KITTITAS COUNTY COMMUNITY DEVELOPMENT SERVICES

January 16, 2015

RE: Sullivan Short Plat, SP-14-00005

The Kittitas County Community Development Services Department has determined that the Sullivan Short Plat (SP-14-00003) is a complete application and hereby grants *conditional preliminary approval* subject to the following conditions:

DATE: 08/2014  
 JOB NO.: 14085  
 SHEET 1 OF 2

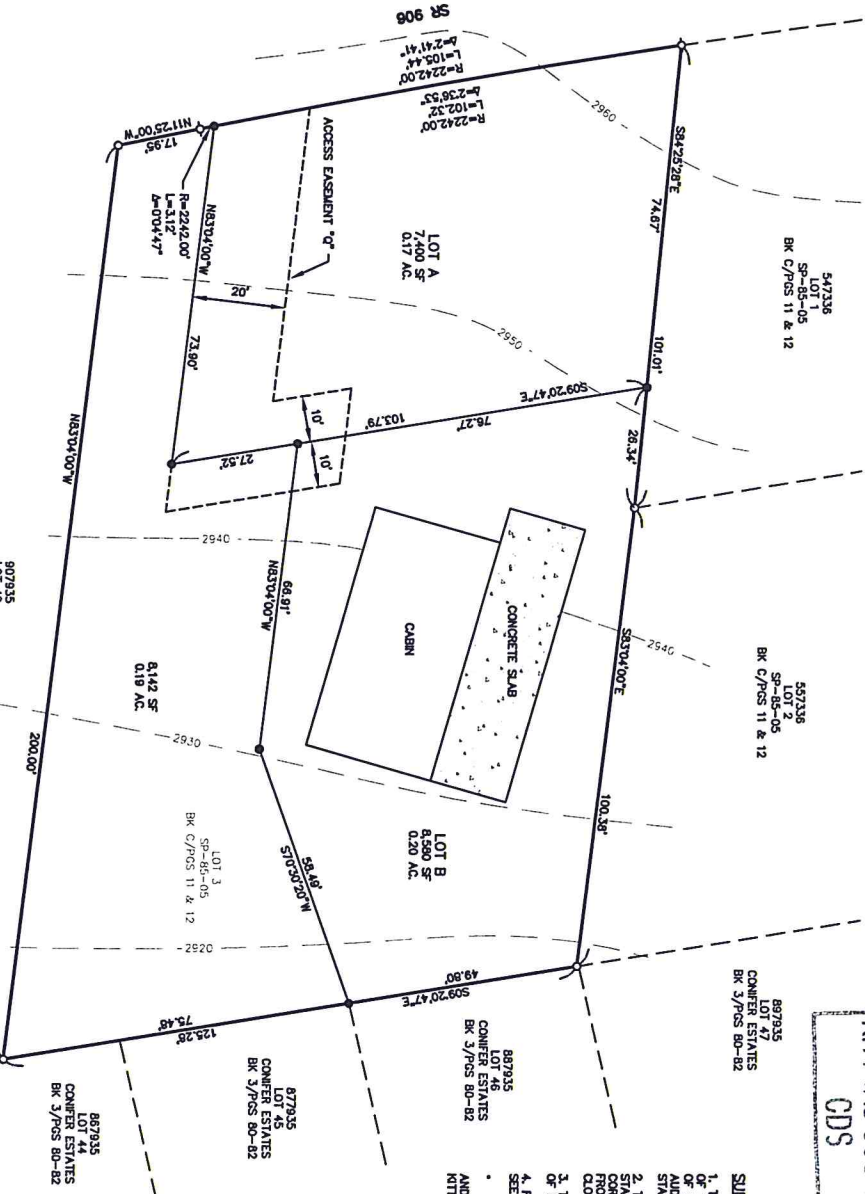
1. Both sheets of the final mylars shall reflect short plat number SP-14-00003 and an accurate legal description shall be shown on the face of the final plat.

3. The following plat notes shall be recorded on the final mylar drawings:

- All development must comply with International Fire Code.
- The approval of this division of land includes no guarantee that there is a legal right to withdraw groundwater within the land division. The approval of this division of land provides no guarantee that use of water under the ground water exemption (RCW 90.44.050) for this plat or any portion thereof will not be subject to curtailment by the Department of Ecology or a court of law.

- Kittitas County will not accept private roads for maintenance as public streets or roads until such streets or roads are brought into conformance with current County Road Standards. This requirement will include the hard surface paving of any street or road surfaced originally with gravel.

- Parking will not be permitted within WSDOT rights-of-way.
- Due to the small nature of these lots, LP- Gas propane tanks will not be allowed on the undeveloped lot, Lot A (15,369 ft²).

- Any new structures or substantial development to existing structures will require a WUI permit Per Kittitas County Code Title 20, 20.10 Wildland Urban interface Code.

8. Confirmation from WSDOT that access to all proposed and existing lots has been attained.
9. Current road standards require a minimum 20' width driveway easement. A minimum of 30' is recommended in order to provide snow storage during the winter season.

14. On the face of the plat designate a snow storage area for all lots associated with SP-14-00003.
